Application for Planning Permission for Works or Extension to a Dwelling

Development: Single storey extension to north elevation.
Location: 20 East Drive Angmering BN16 4JH

Location	Toad hall 20 east drive Angmering BN16 4JH
Drawing	Extensions and alterations to North elevation. Site and block plans
Date	25/06/2026
Scale	1: 1250/500 @ A3
Drawing No	P/TH/10.1
	Cd file iMac

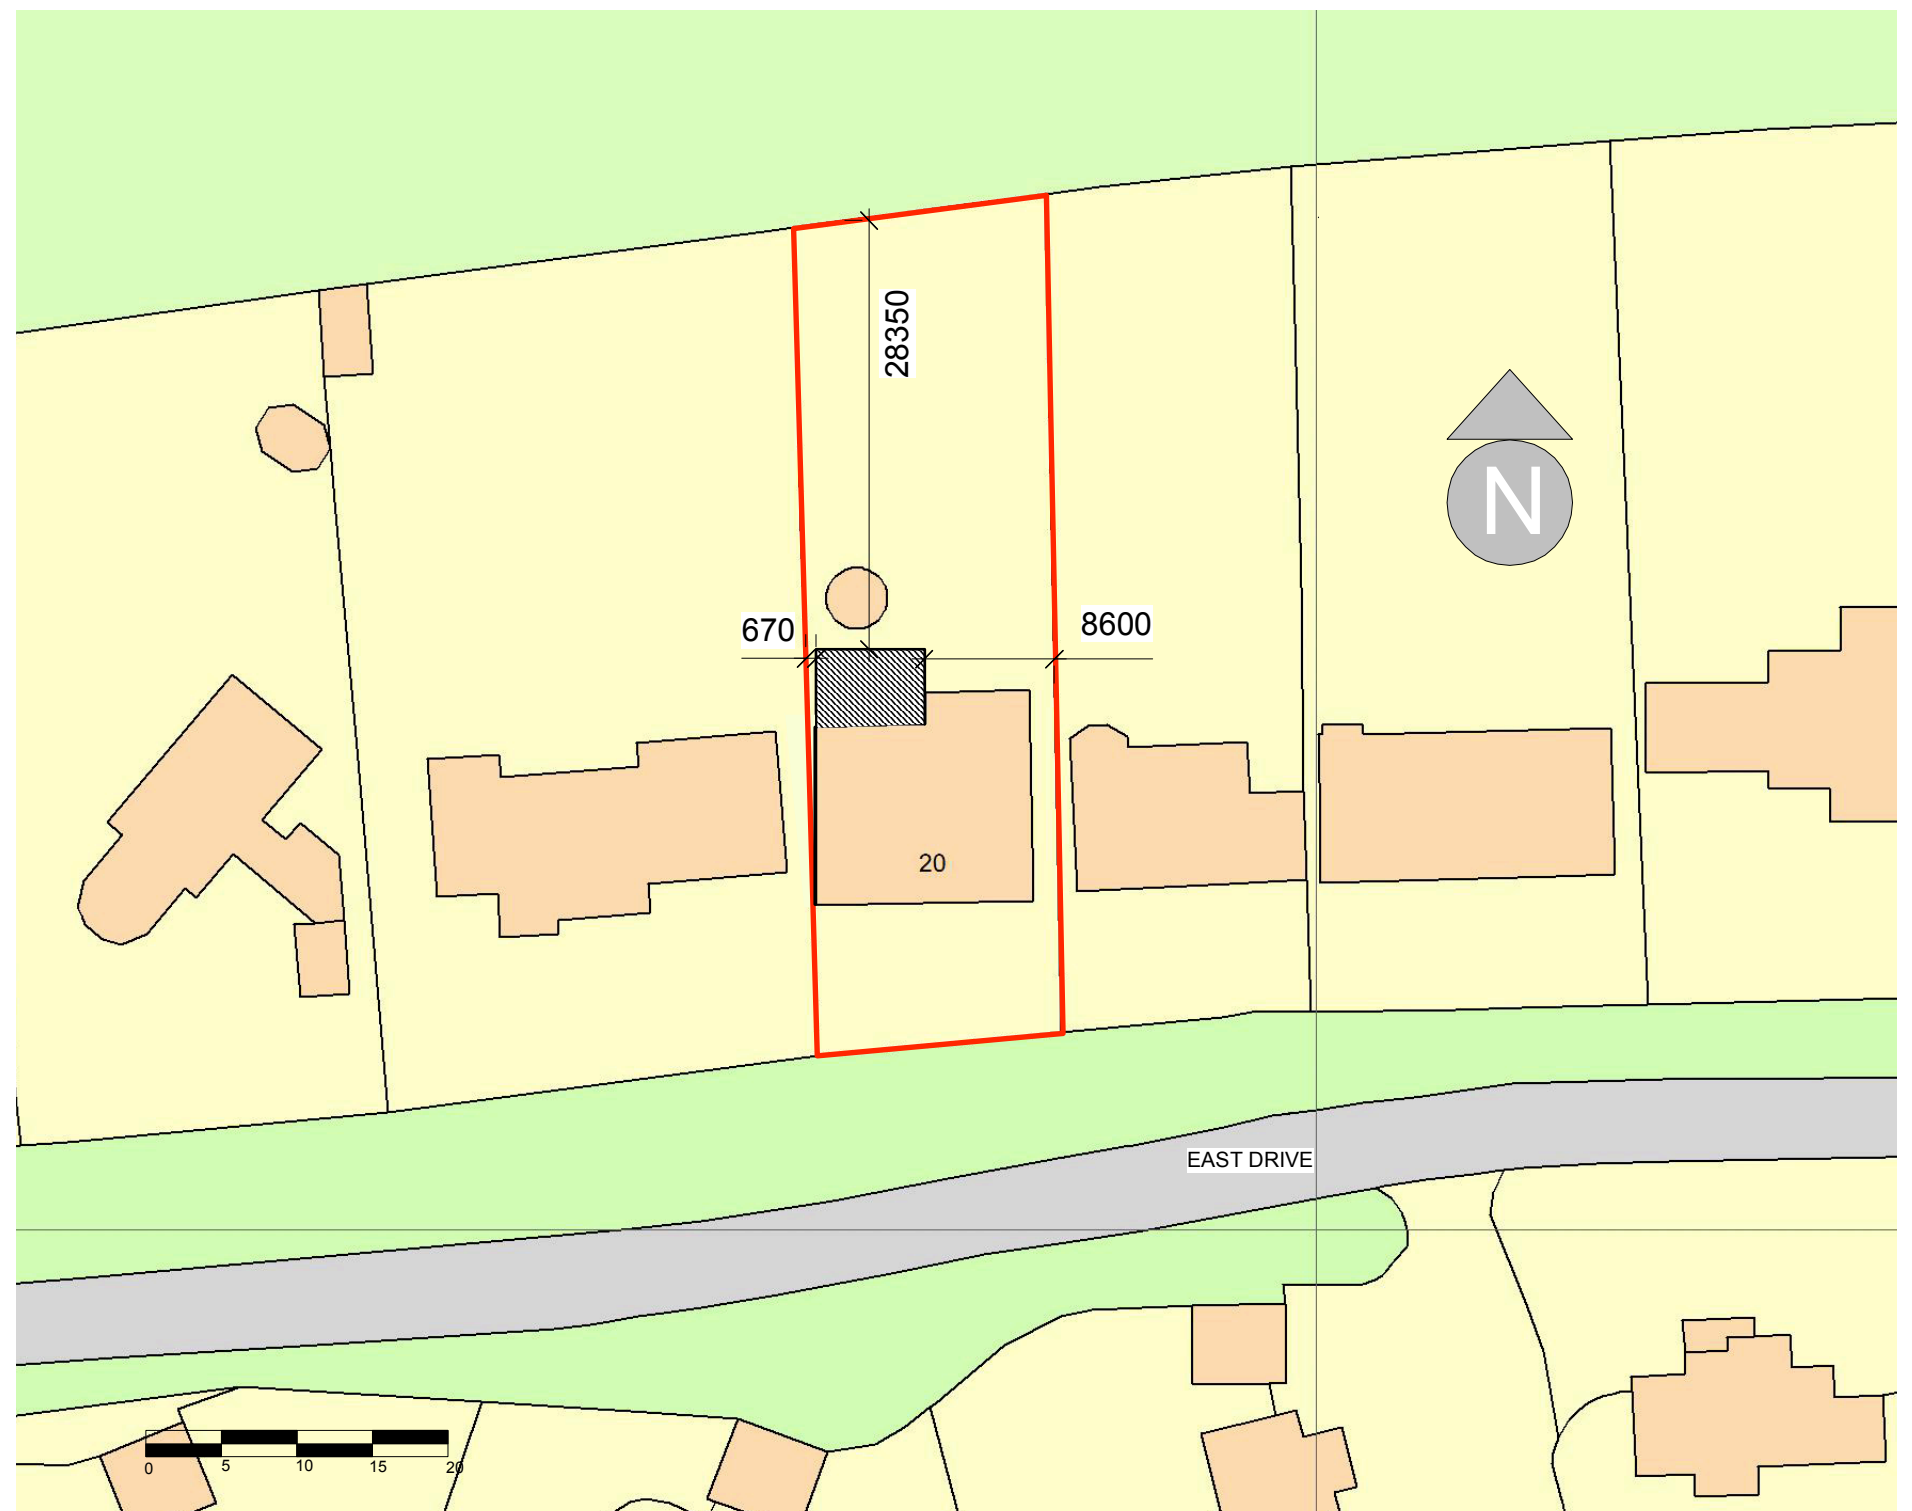
You are required to have dimensions from the proposed extension(s) to all site boundaries. Please amend.

In addition to the above, the width of the extension is inconsistent between the block plan and the proposed plans, please review and amend.

ROOFSCAPE 1:200

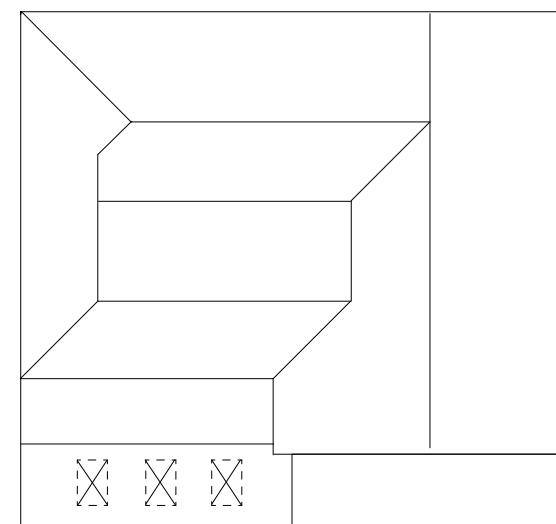
Please submit electronic plans showing the existing roof plan. Please refer to the Validation Requirements List for further details.
